## DEPARTMENT OF PARKS AND COMMUNITY SERVICES

November 3, 2023

**Subject: Mayberry Sketch Plan, Preliminary Comments (SKP236)**

Regional Trail

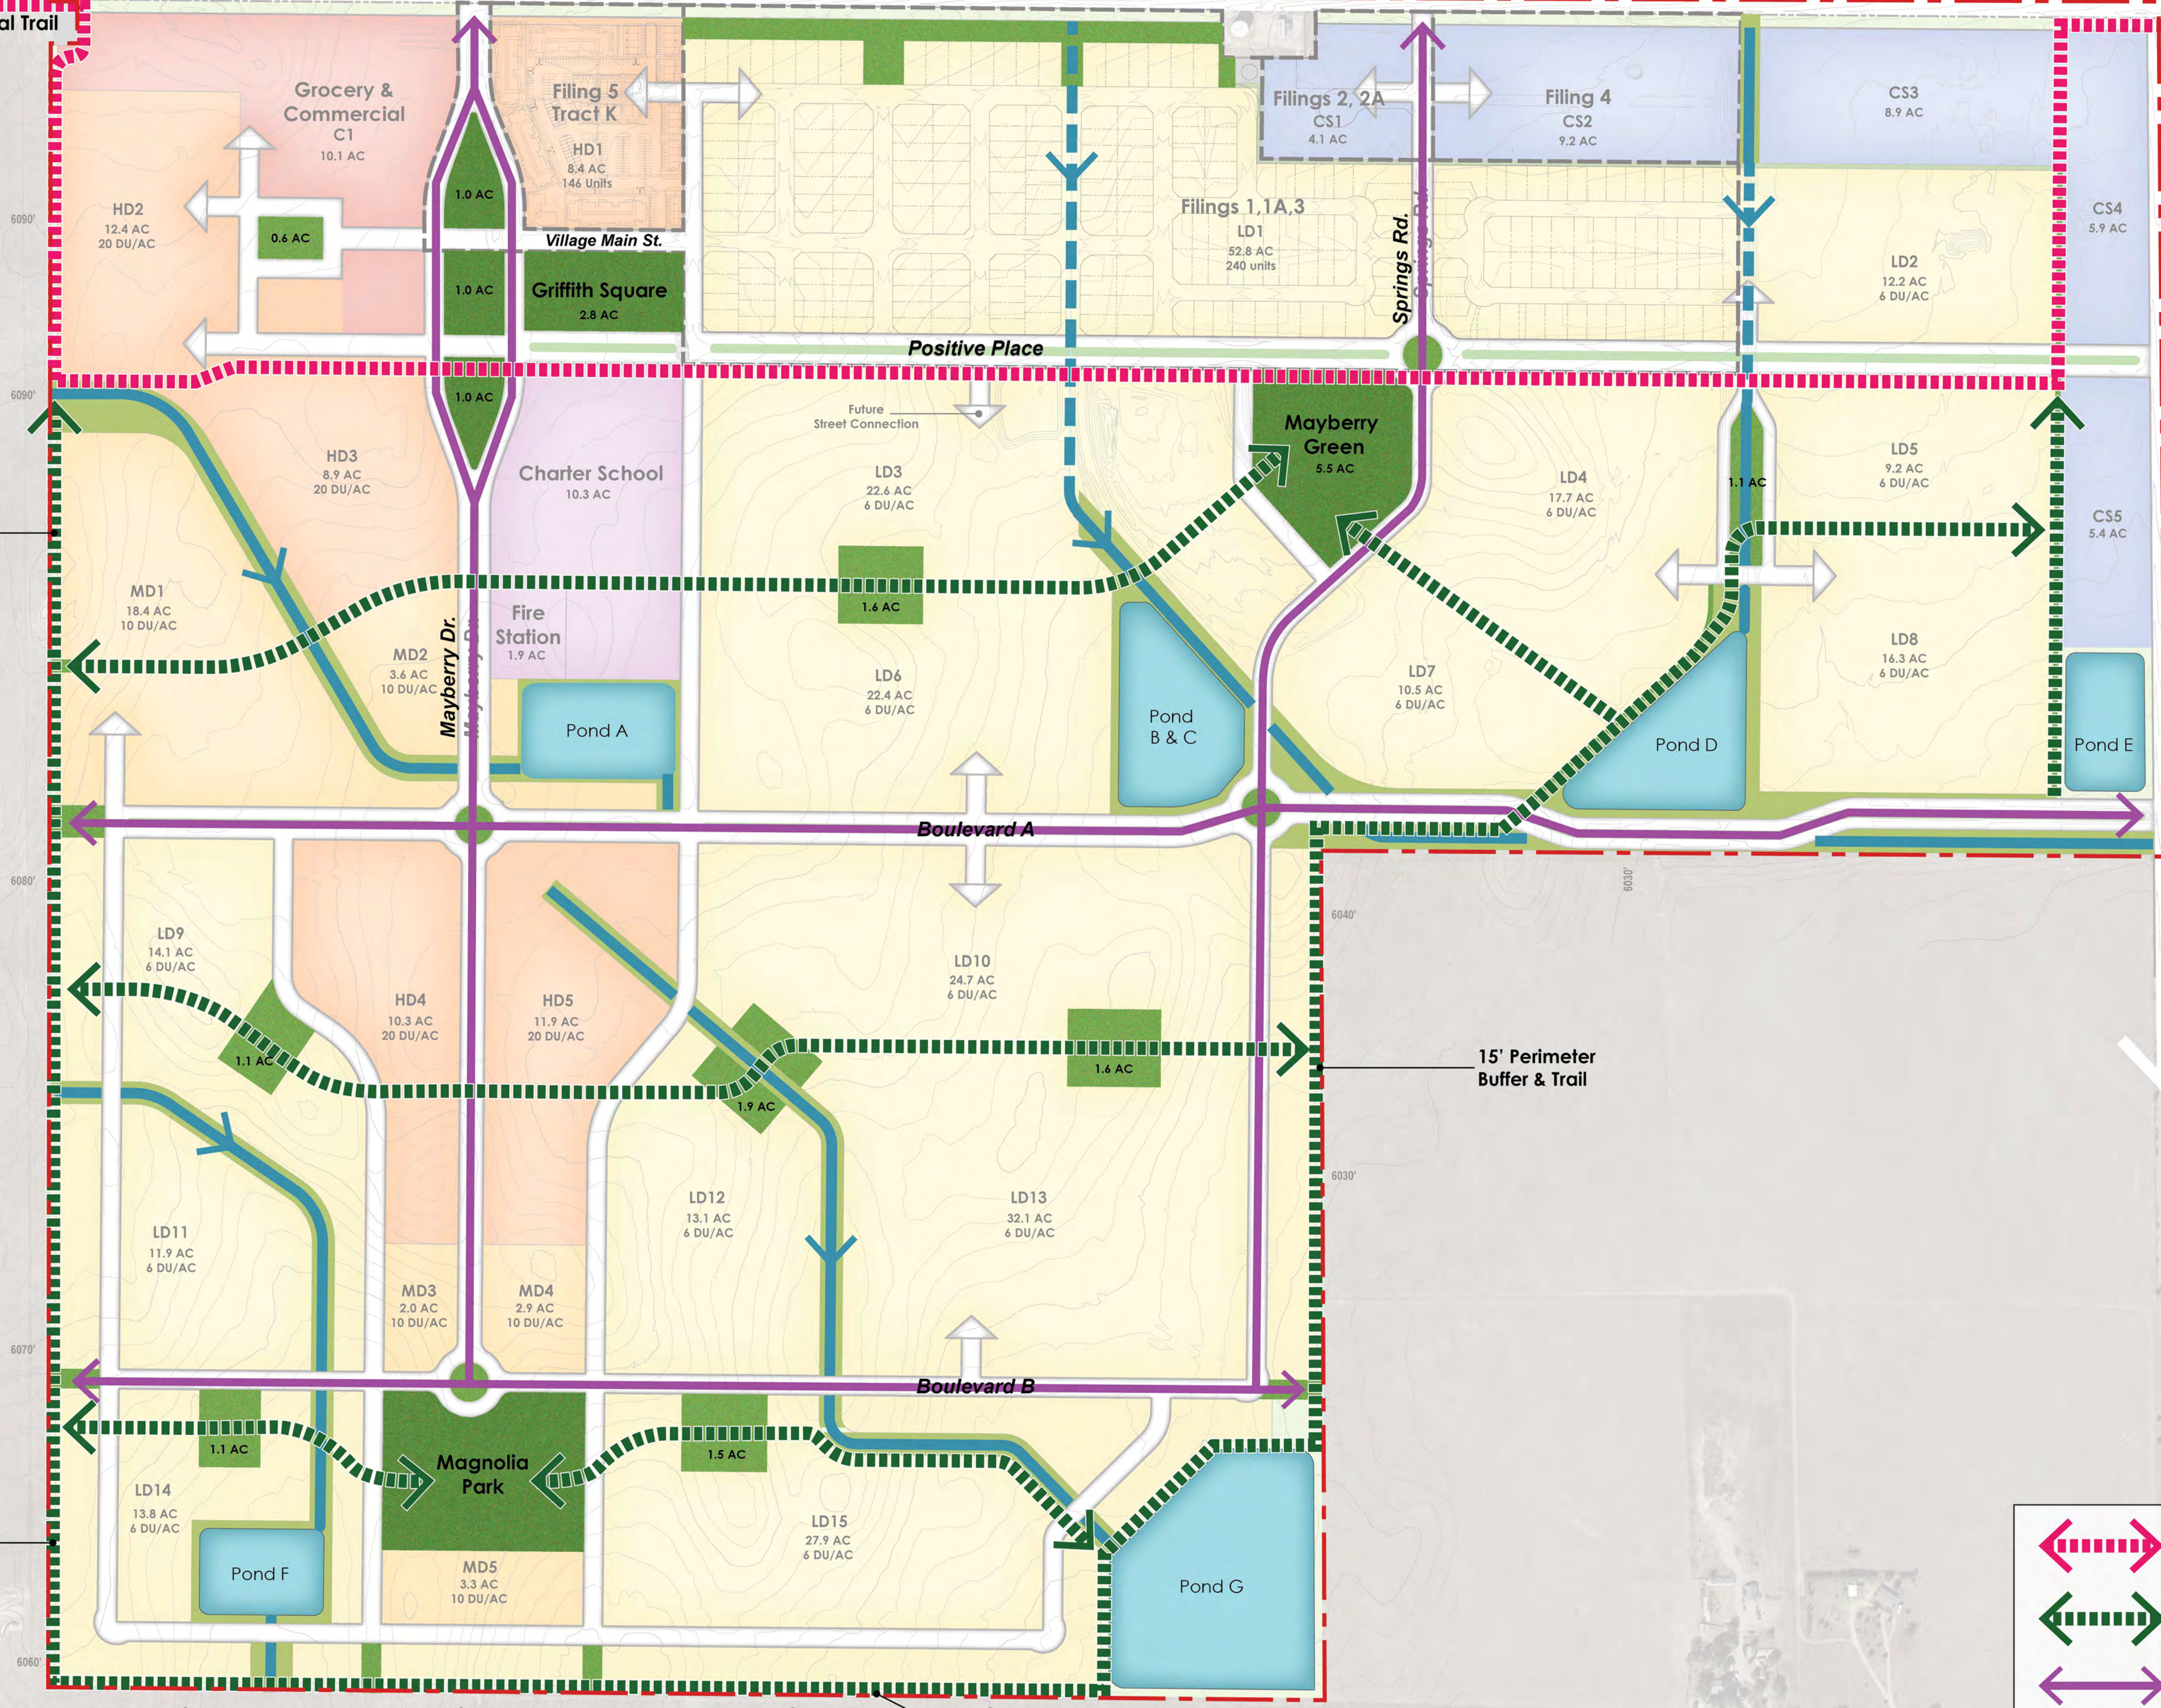
The Highway 94 Regional Trail easement has previously been recorded as a trail easement to El Paso County on Mayberry Filings 1-4. The 25' wide trail easement is on the south side of Highway 94 on the previously dedicated easements. The current sketch plan shows a 'Regional Trail' following the Highway 94 at each end of the proposed development, then going south approximately 1,100' before turning into an east-west trail. The Highway 94 Primary Regional Trail is a trail that will connect Ellicott, CO to Colorado Springs, CO and will be 10 miles long when completed. As a regional trail connecting communities, it will not have tangents and instead will have a straight alignment following the southside of Highway 94. The regional trail needs to be adjusted closer to the mater-planned trail alignment.

El Paso County Parks recommends that the applicant designate and provide to El Paso County a 25-foot trail easement along the south side of Highway 94 that allows for public access, as well as construction and maintenance by El Paso County of the Highway 94 Primary Regional Trail, and show the easement on the forthcoming Preliminary Plan and Final Plat(s), and dedicate the aforementioned easement to El Paso County prior to the recording of the Final Plat(s).
